Our Ref: P/70/19/RES

The Town & Country Planning Act 1990 (as amended)
Town & country Planning (Development Management Procedure) (England) Order 2015 - Article
6

Application for Approval of Reserved Matters Following Outline Approval

- Development** Approval of reserved matters following outline consent P/58/15/OUT for 90 No. dwellings.
Also seeking to address the terms of planning conditions 6 (Phasing), 8 (ecology), 9 (Surface Water), 12 (Vehicular Access), 15 (Parking), 18 (Travel Plan), 20 (Landscape Management), 24 (Parking Control), 25 (Dwelling Parking) and 26 (Materials)
- Location** Land North of Summer Lane Pagham

DRAWING STATUS	SCALE
PLANNING	1:100 @ A1
PROJECT NO. DRAWING NO.	REVISION
1177 PD110	E
	CG

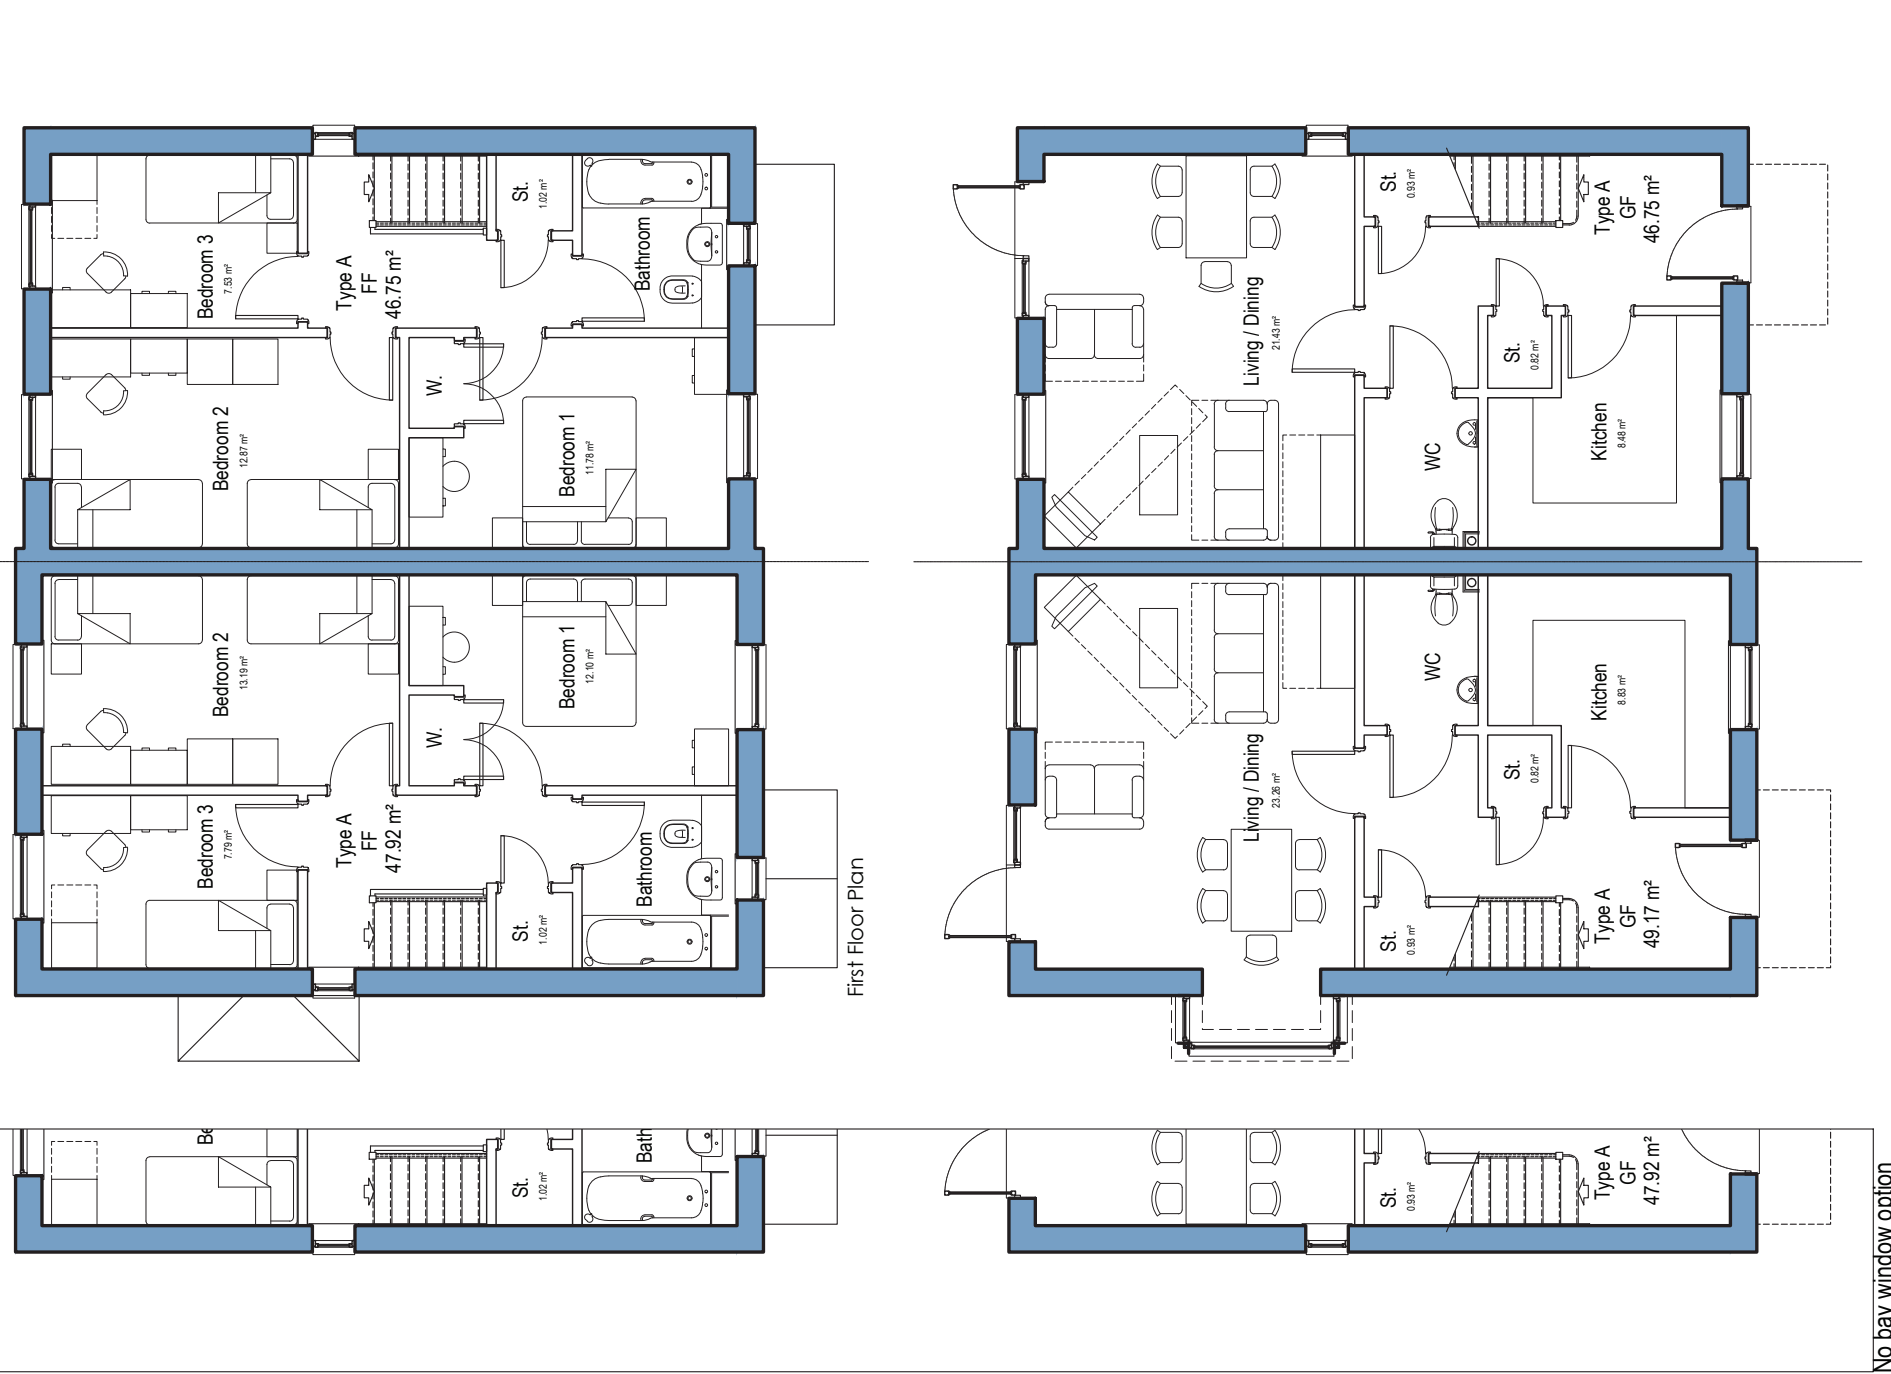
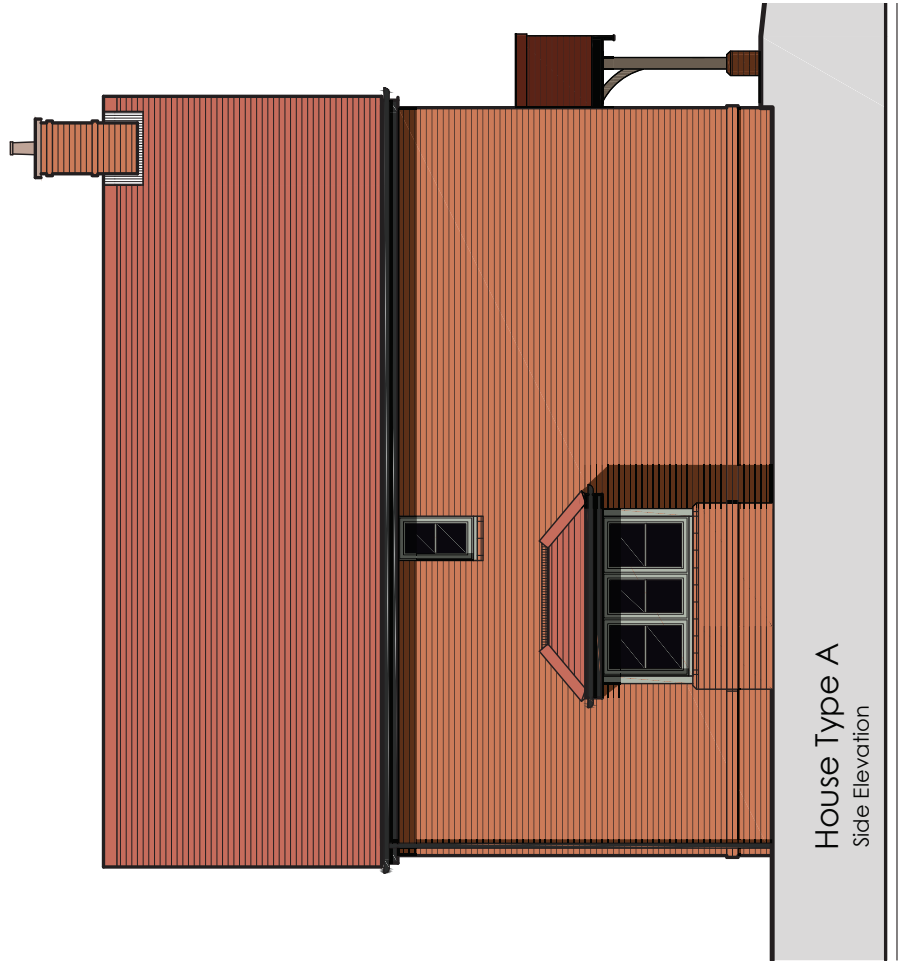
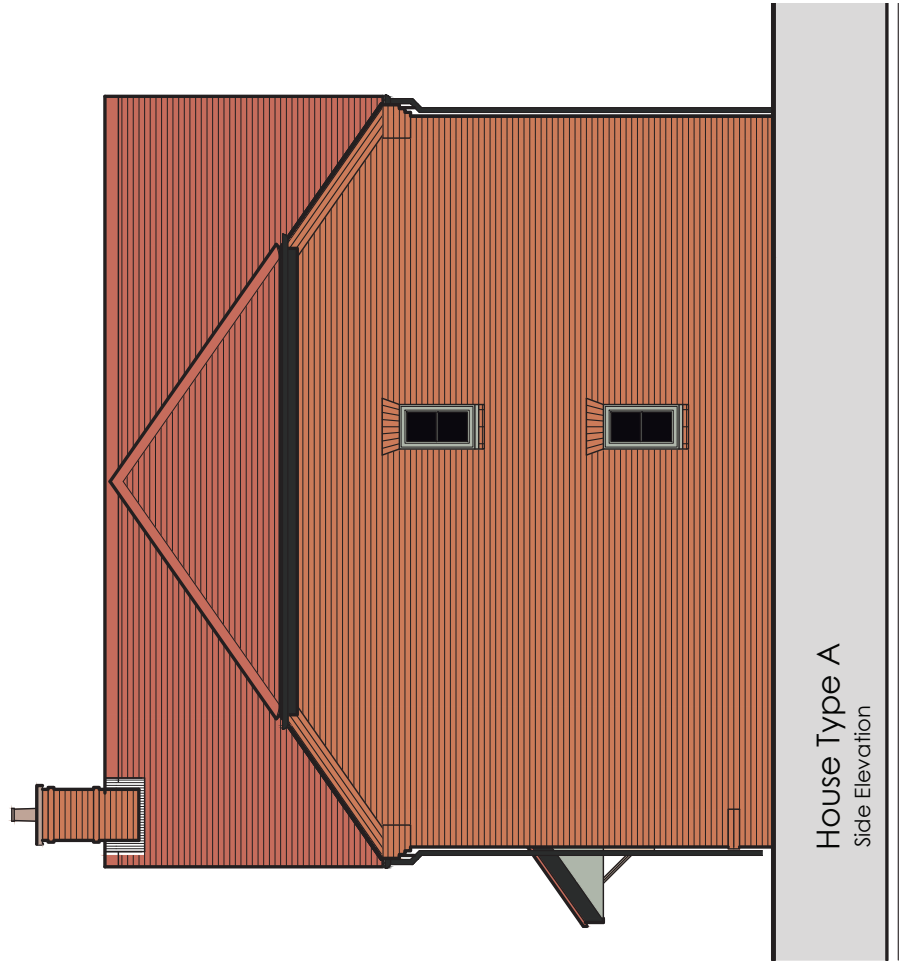
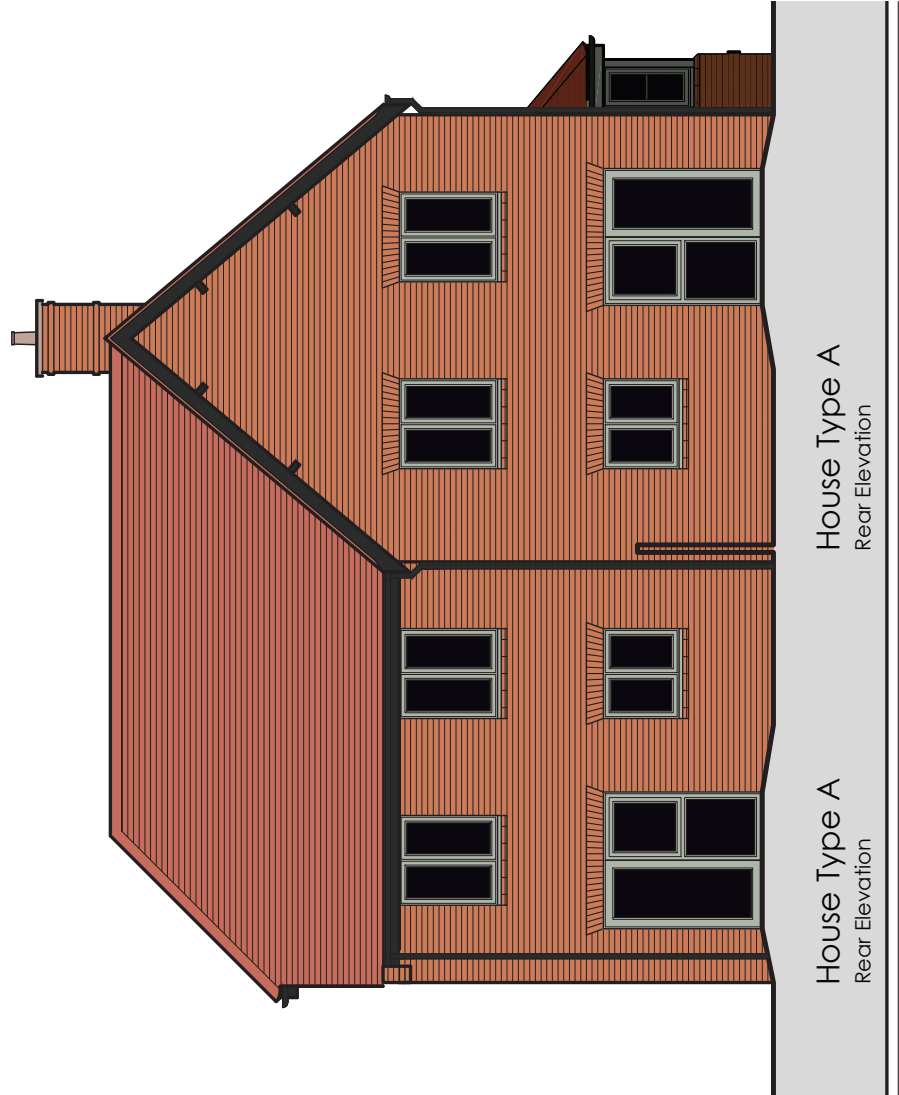
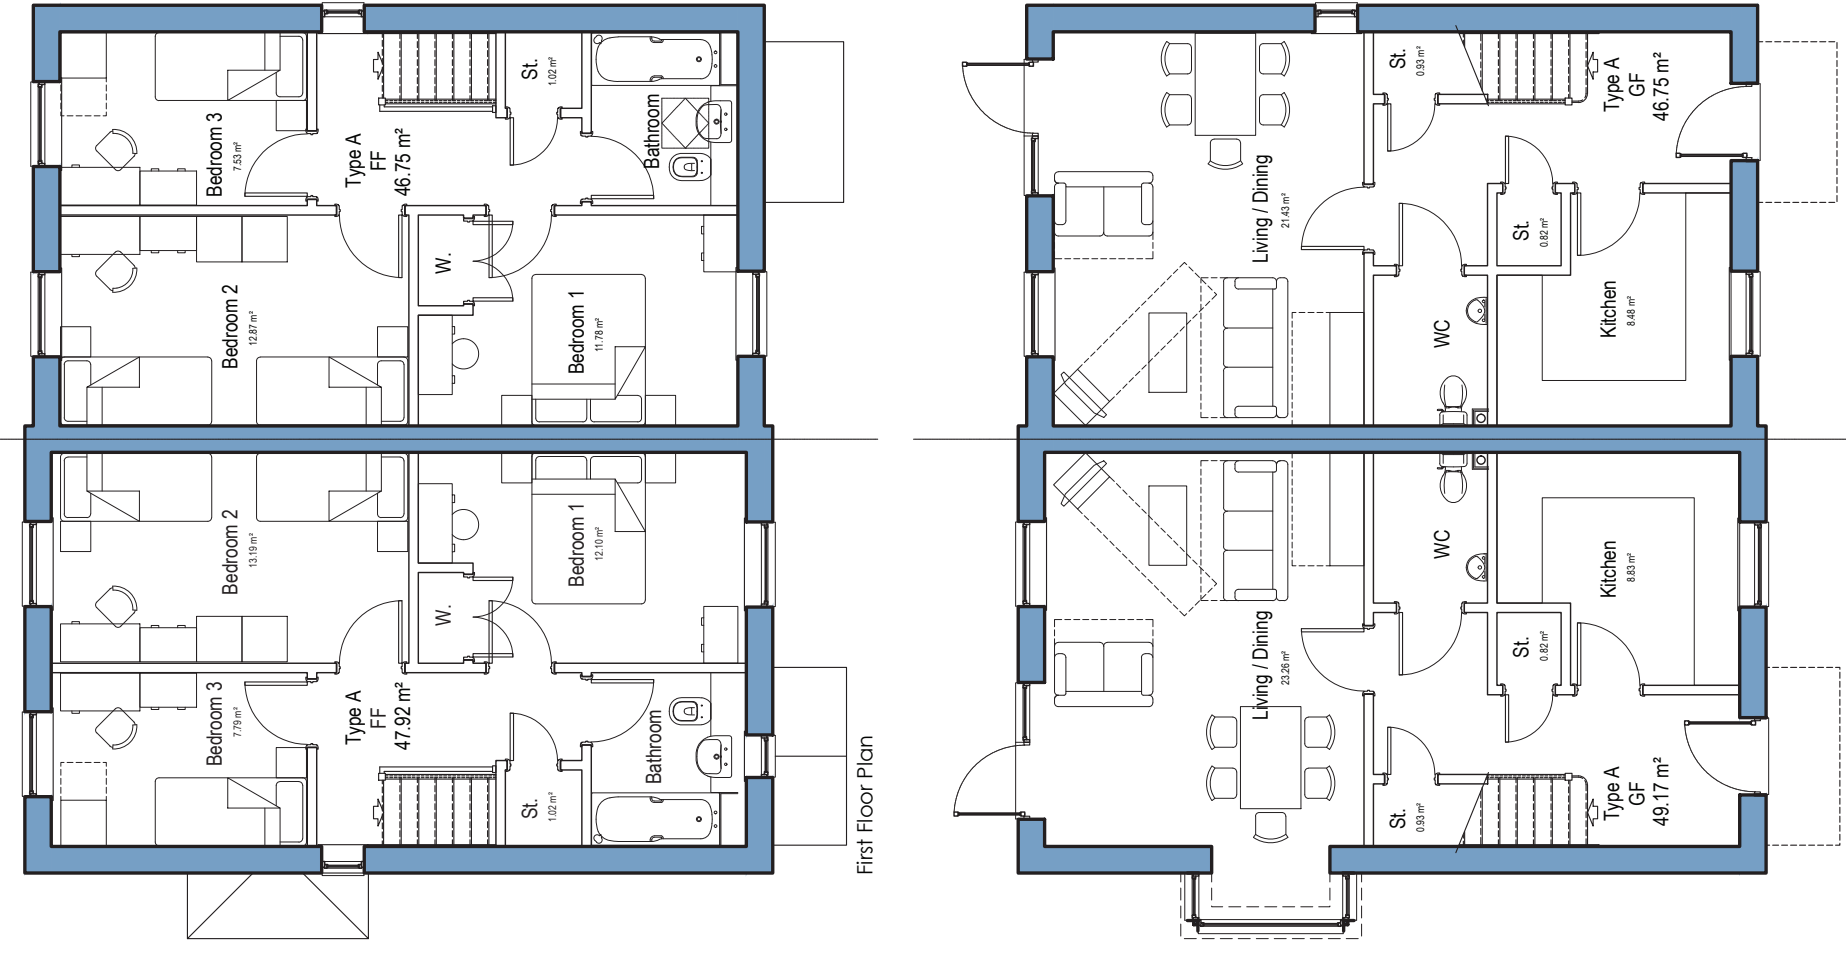
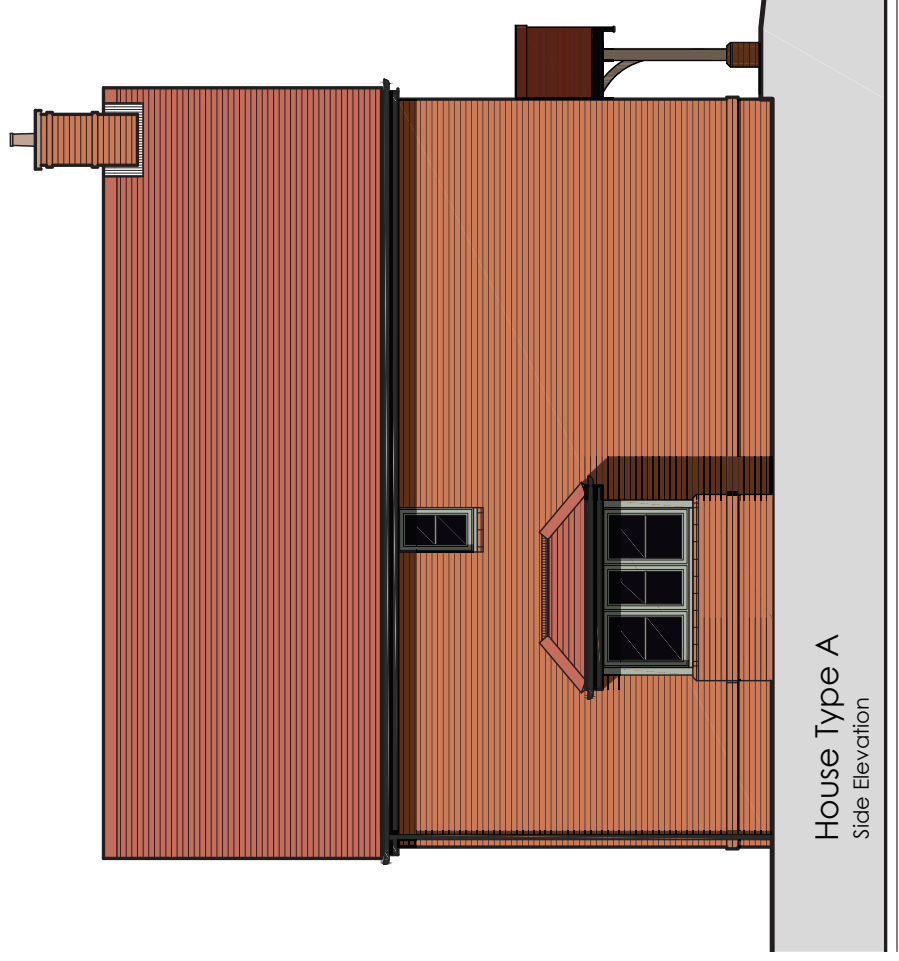
On plan 110 rev C, the side elevation and ground floor plan do not accord. Please amend accordingly.
